BOLTON-BY-BOWLAND, GISBURN FOREST & SAWLEY PARISH COUNCIL

PLANNING APPLICATION NO: 0804/5
RELATING TO RODHILL LODGE, BOLTON-BY-BOWLAND

SECTION

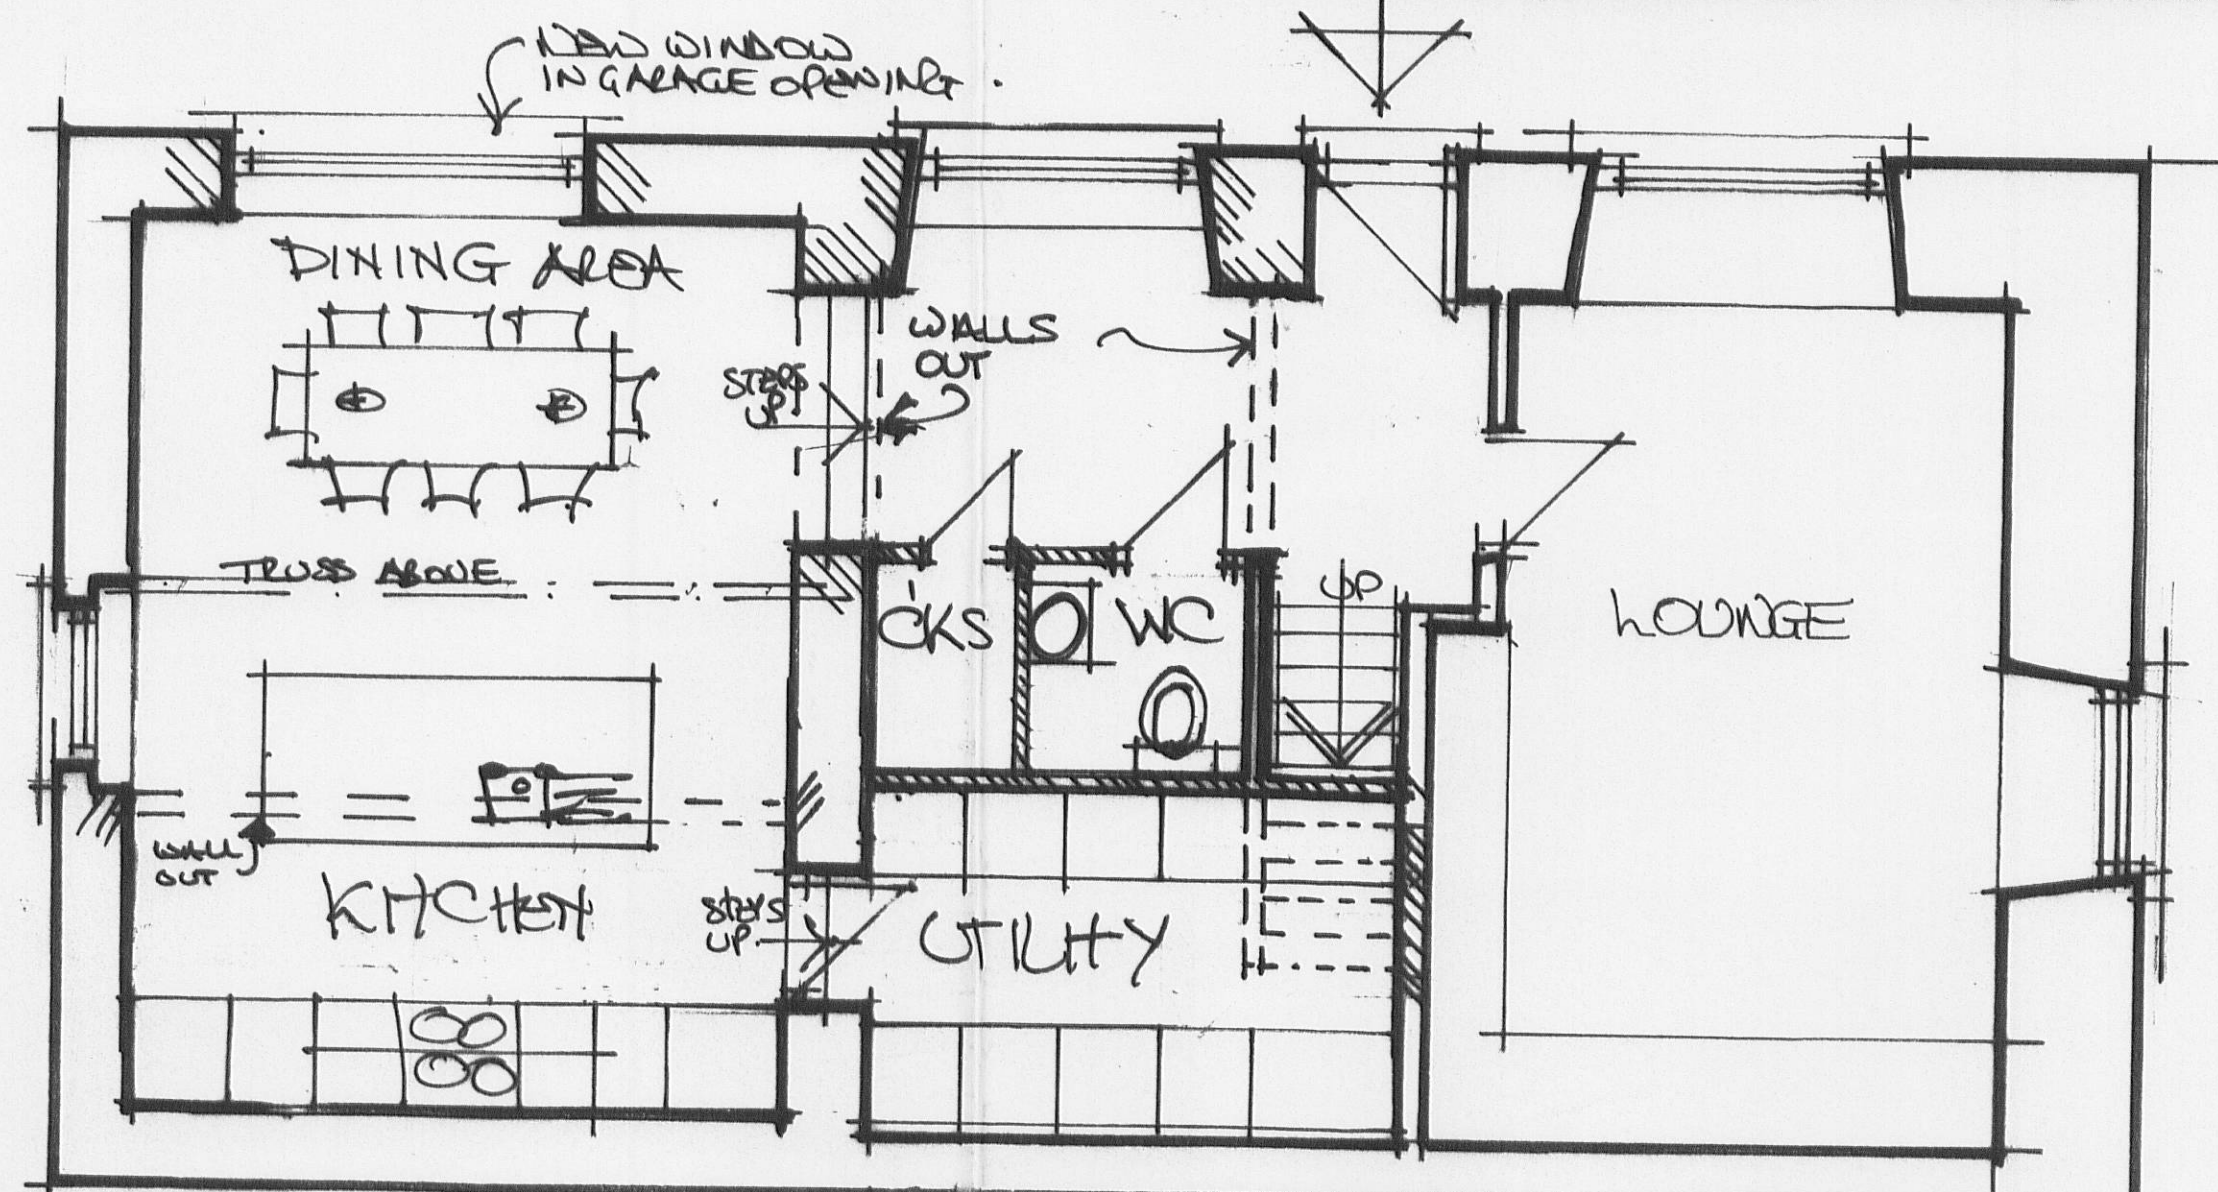
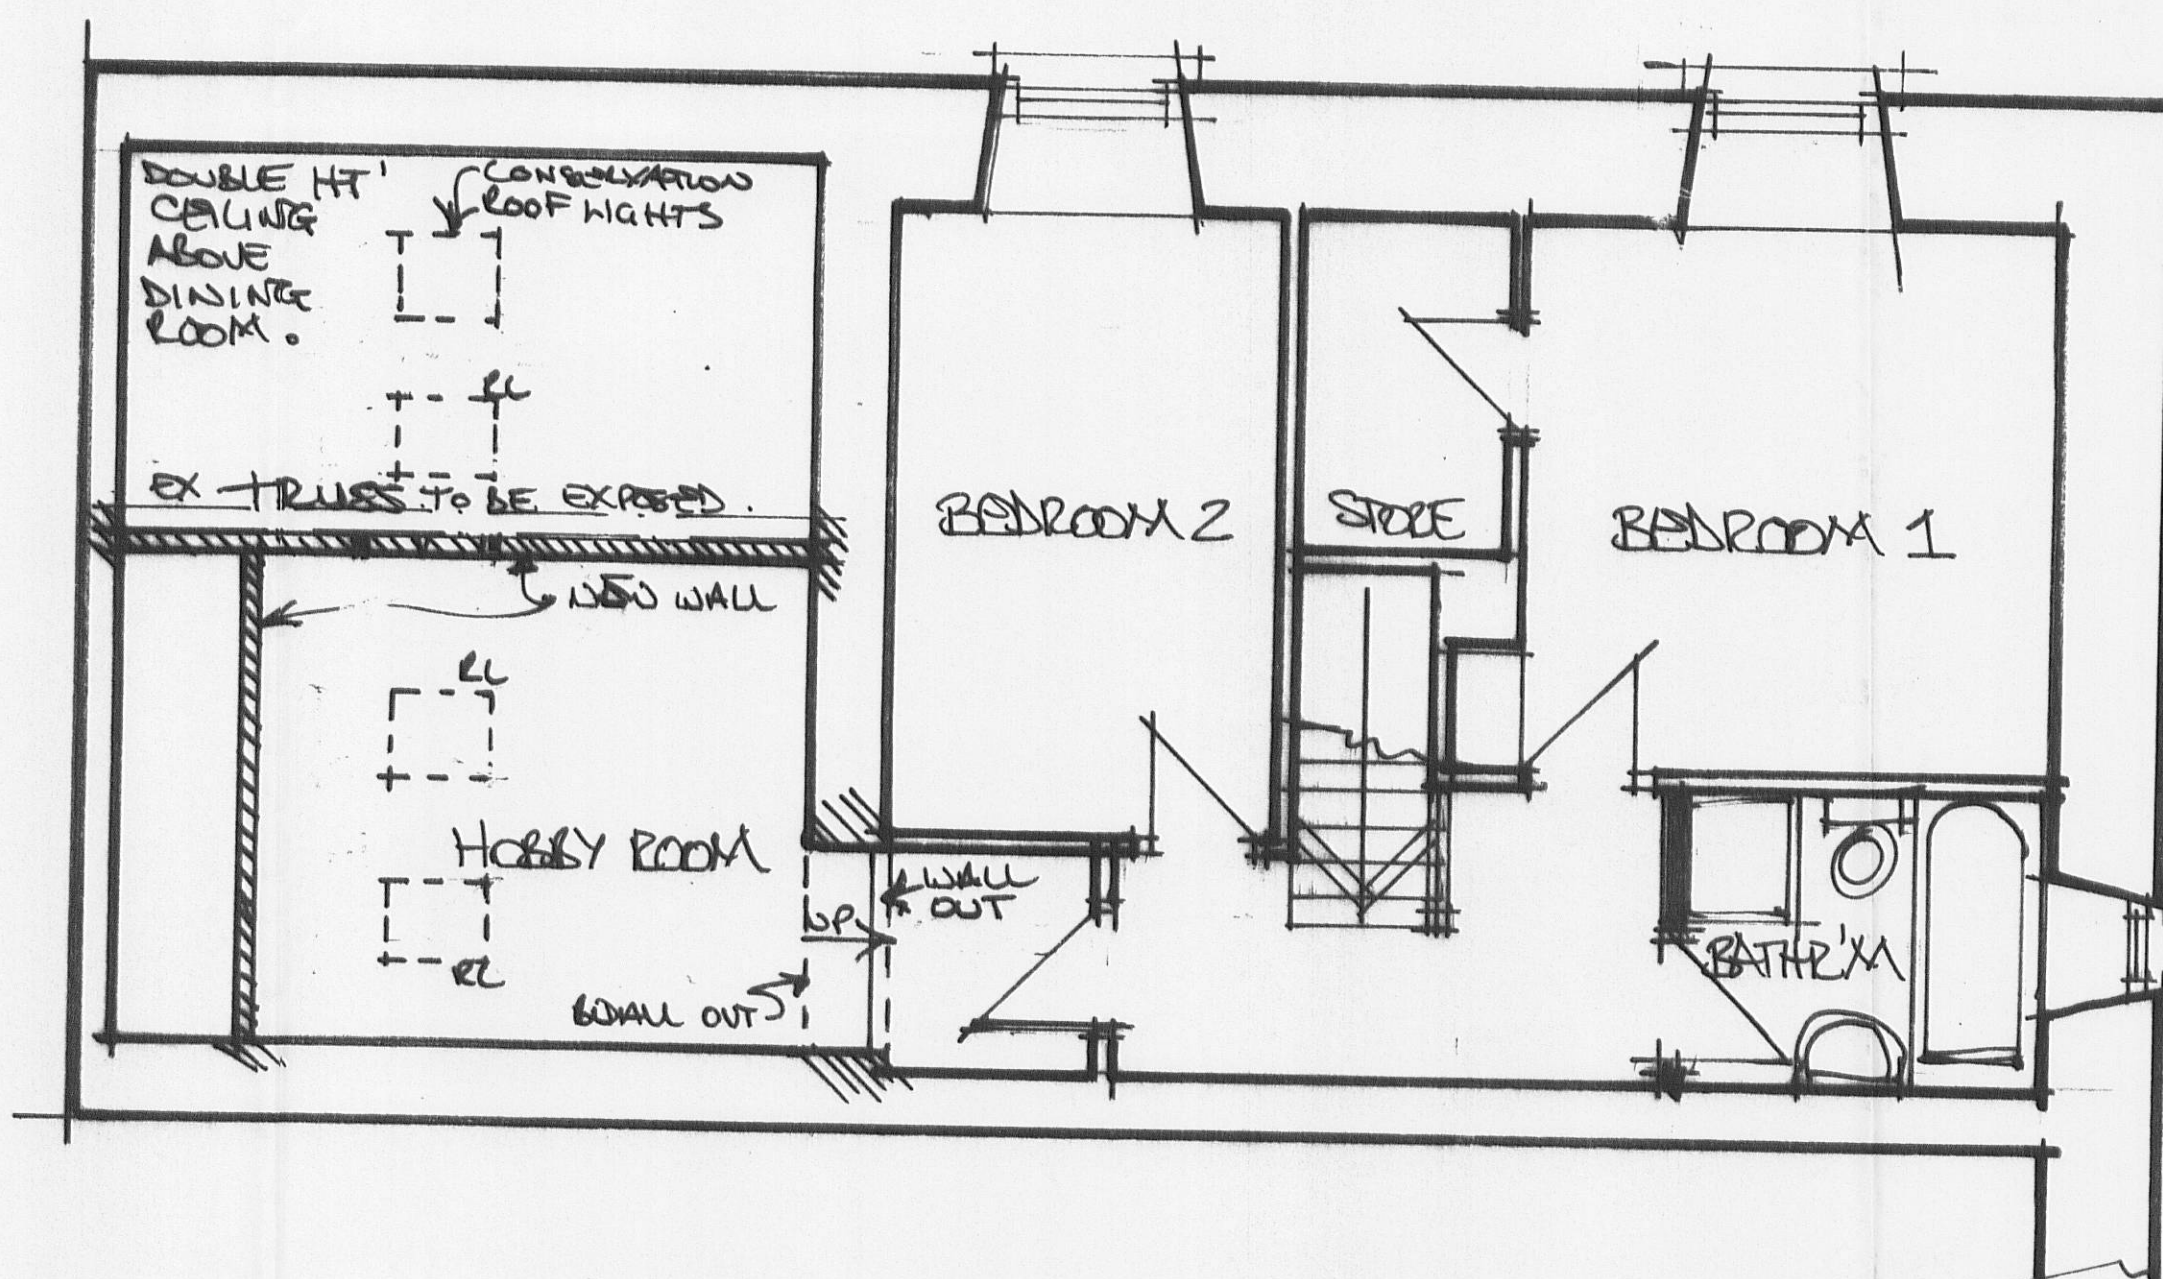
QUERY THE NEED FOR 4 ROOF
LIGHTS ABOVE LOBBY ROOM
